Q. no.	QUESTION	SOUTH DERBYSHIRE DISTRICT COUNCIL REPLY
1.2	<p>Articles 11(7), 14(9), 16(6) confer deemed consent if the authority does not respond within 28 days (a “guillotine”). The Applicant [AS-017] considers that these provisions are necessary to ensure that delivery of the Proposed Development is not unnecessarily delayed.</p> <p>a) Do DCC, SDDC and the EA consider that the 28 days period is reasonable?</p> <p>b) Should provisions be added for any application for consent to contain a statement drawing the authority’s attention to the guillotine?</p>	<p>SDDC considers the 28-day period to be very tight, particularly if consultation between authorities is required. 28 days does not give much time for communications between local authorities, with internal consultees, or the Applicant.</p> <p>SDDC would ask that provision is made for the authority’s attention to be drawn to the guillotine.</p>

Figure 15.1: Agricultural Land Classification results

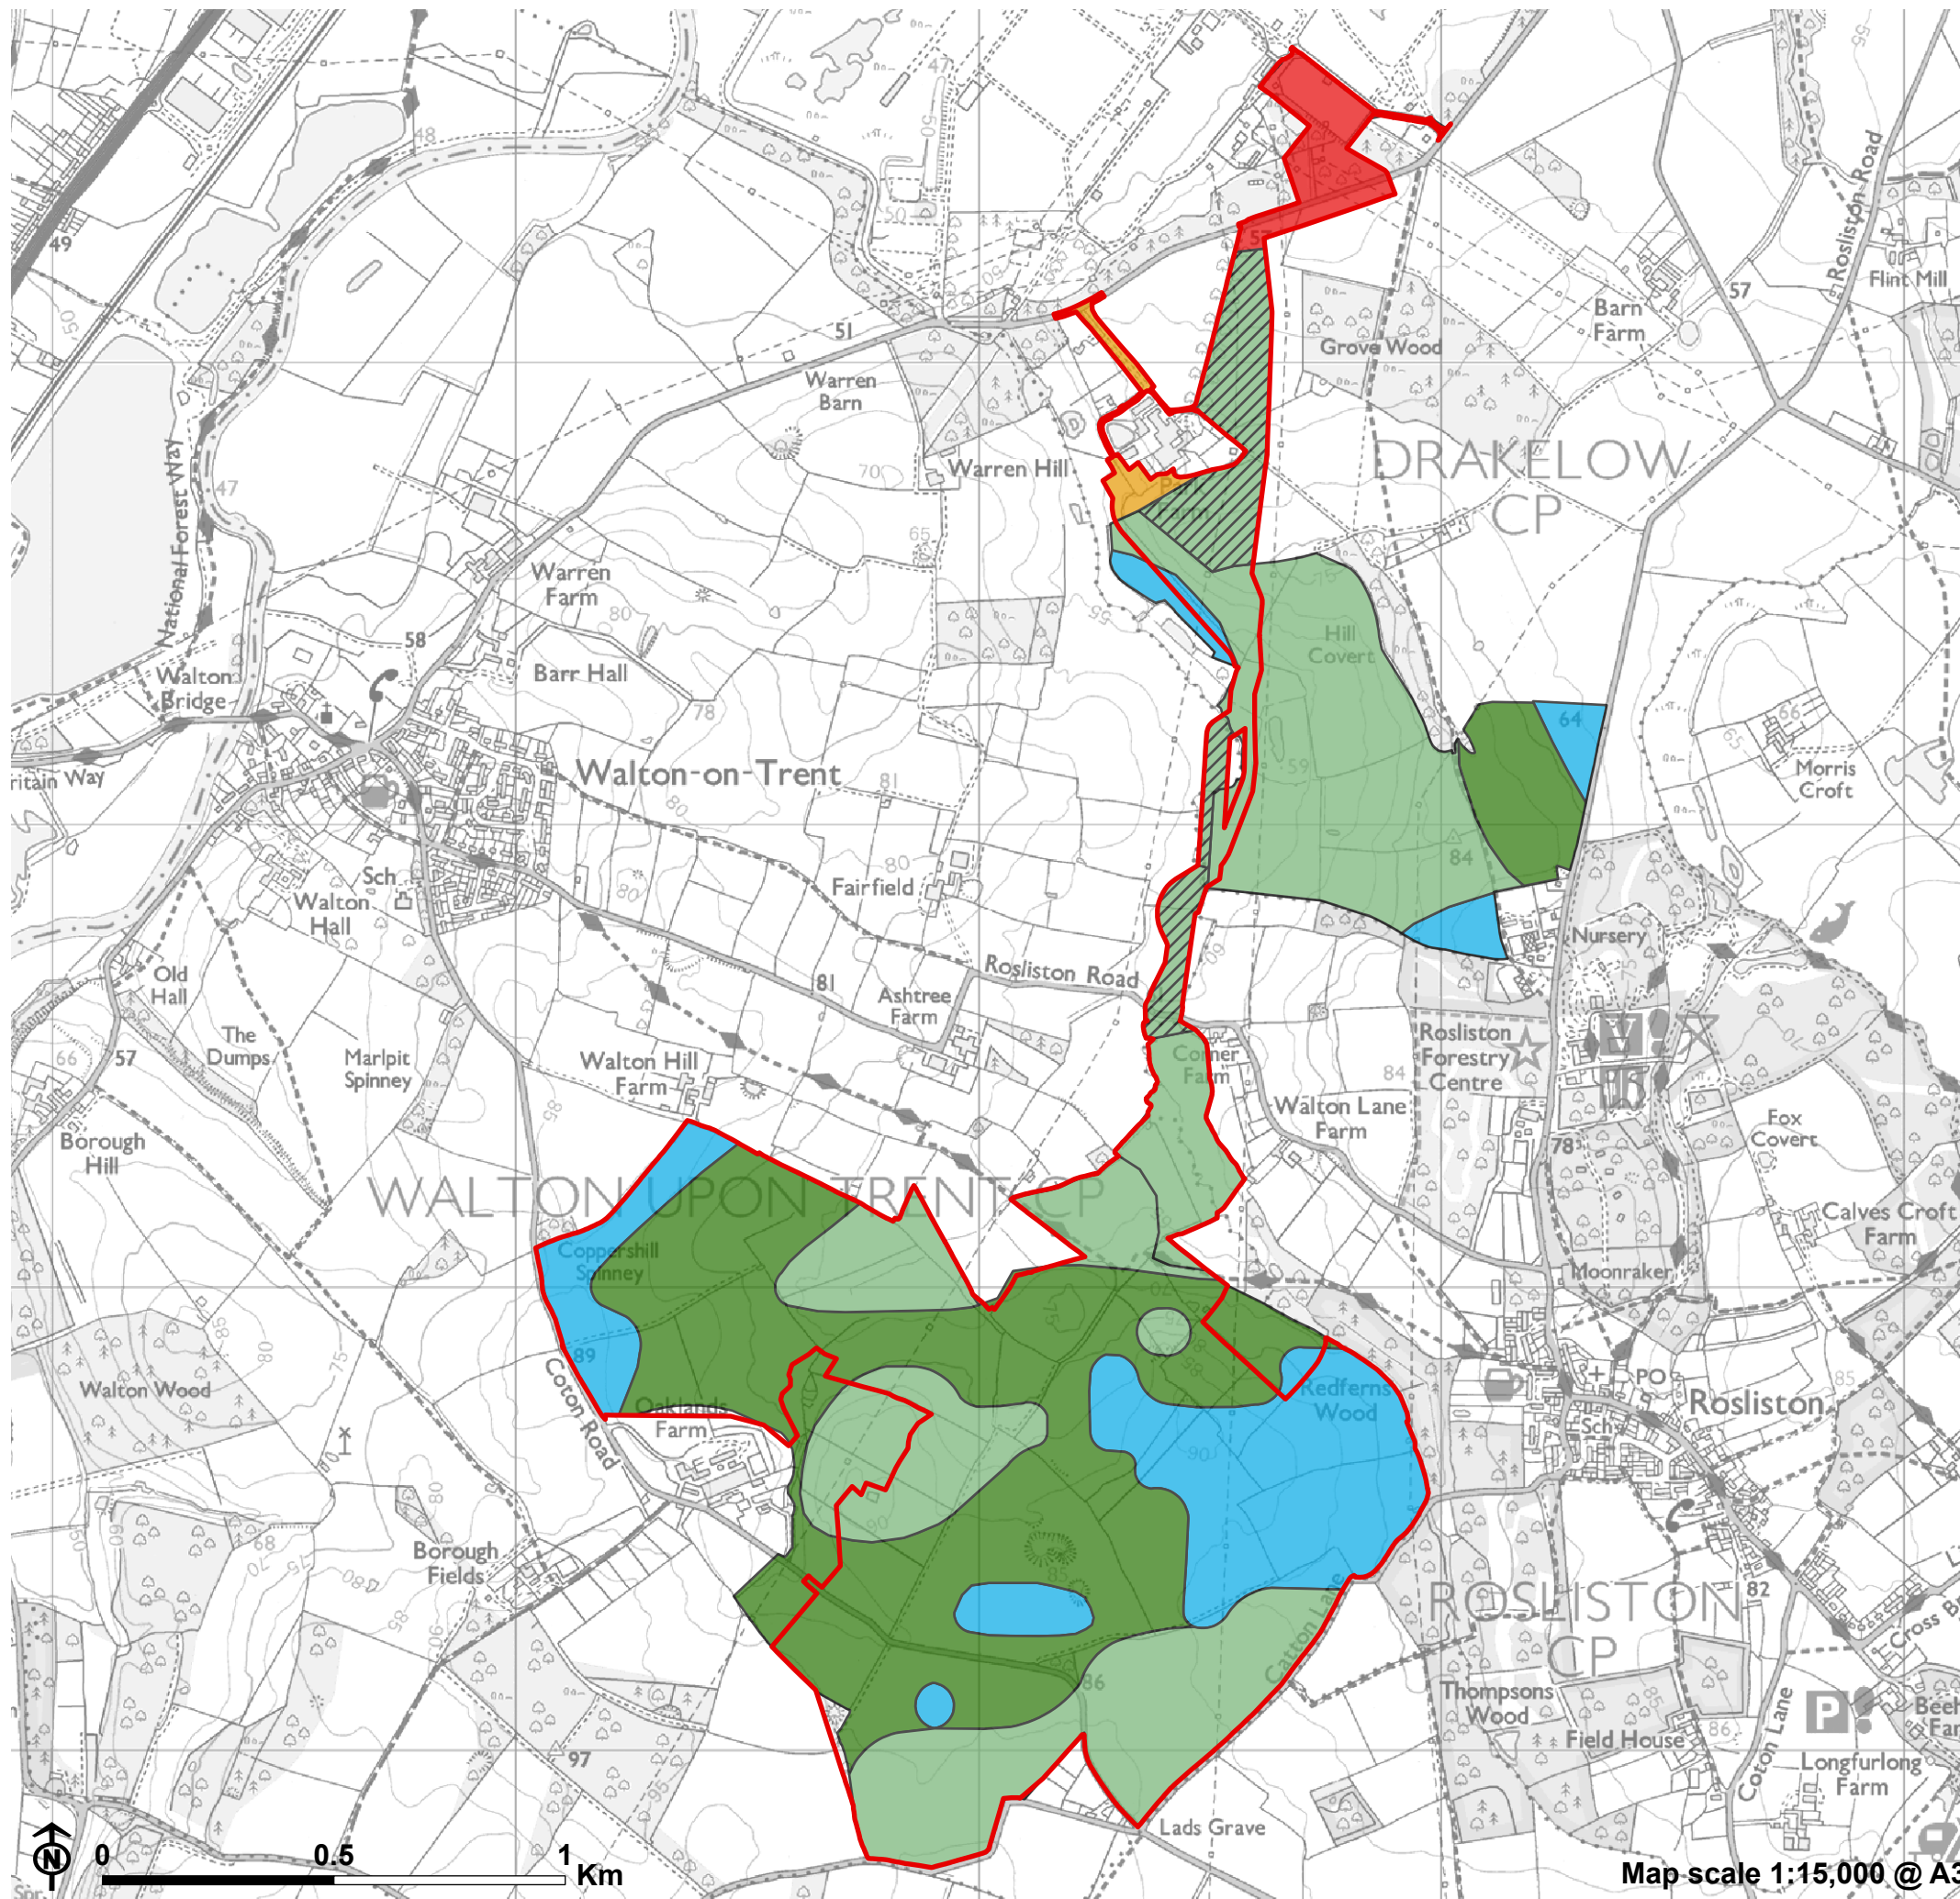
<p>6.2</p>	<p><u>Agricultural Land Classification (ALC)</u> Paragraph 2010.33 of NPS EN-3 states that the ALC is the only approved system for grading agricultural quality in England and, if necessary, field surveys should be used to establish the ALC grades in accordance with grading criteria and identify the soil types to inform soil management at the construction, operation, and decommissioning phases in line with the DEFRA Construction Code.</p> <p>a) Are NE and SDDC content with the Applicant’s ALC and surveys [APP-168, APP-169, APP-170, APP-171]?</p> <p>b) Is Subgrade 3b a robust worst case assumption for the areas that were not surveyed [APP-168]?</p> <p>c) Should surveys be required of areas that were not surveyed to rule out that they could be BMV agricultural land?</p>	<p>a) It is considered that they meet the minimum criteria of MAFF 1988, but soil survey work was not supervised/observed.</p> <p>b) Yes, this is the most likely grade.</p> <p>c) Only where land is shown on provisional maps to be higher than Grade 3 or on the Likelihood of BMV map as moderate to high likelihood of BMV.</p>

<p>6.6</p>	<p><u>Potential permanent loss of agricultural land</u> The Applicant [APP-169 paragraph 15.134] states that the Battery Energy Storage System and onsite substation would be removed during decommissioning, but that the land in these areas may not be restored back to the same ALC grade. The Battery Energy Storage System and substation would be within a small field of mixed Subgrade 3a and 3b quality. The Applicant indicates that there would be a permanent loss or downgrading of 1.5ha of Subgrade 3a agricultural land if the substation was not removed or suitably restored.</p>	<p>a) If cables are left in-situ this would result in land drains not being reinstated so there would be a permanent loss.</p> <p>It would be reasonable for the dDCO to require no permanent loss of Subgrade 3a land.</p>
